**Hera Gold Project (10_0191)
Exhibition of Environmental Assessment**

I refer to your letter dated 8 November 2011 regarding the YTC Resources Limited proposal to develop the Hera Gold Project. NSW Trade & Investment, Regional Infrastructure & Services (DTIRIS), Division of Resources & Energy (DRE) has reviewed the *Hera Project via Nymagee Environmental Assessment* dated November 2011 (EA) and provides the following comments which are directed at specific areas of DRE responsibility for this proposal:

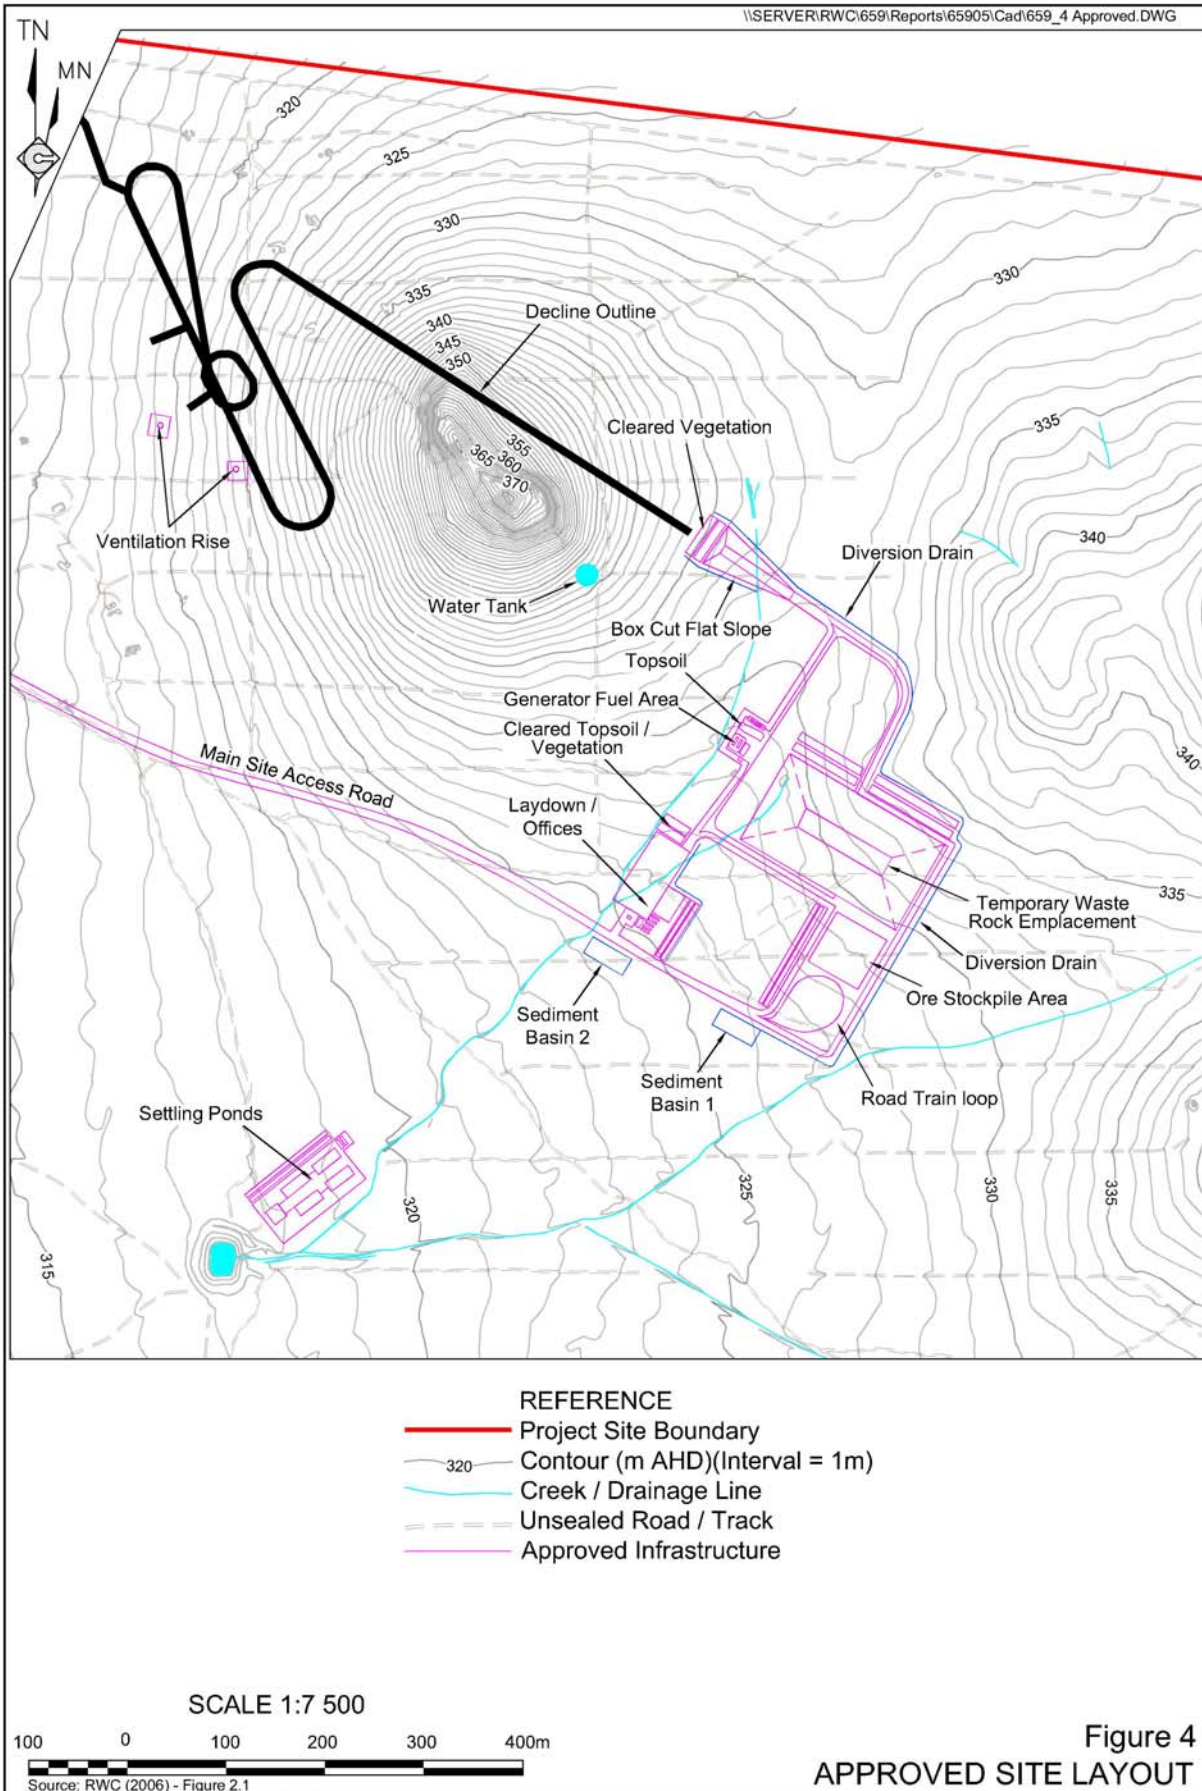
- The Hera EA states that "A number of components were approved by the then Department of Primary Industries in 2006 under Part 5 (sic)....."
- The EA then proceeds on the assumption that these components do not require further approval under the *EP&A Act 1979*.

- These components were approved as a temporary exploration activity under the *Mining Act 1992* (and were subject to a Part 5 assessment under the *EP&A Act 1979*).
- The exploration activity approval is specific to the exploration licence (EL).
- When/if a mining lease is granted, the EL will be cancelled over the mining lease area.
- Cancellation of the EL will mean that the exploration activity approval will be voided.

The outcome of all of this is that the EA/project application needs to cover all components of the proposed activity and the EA should be amended accordingly.
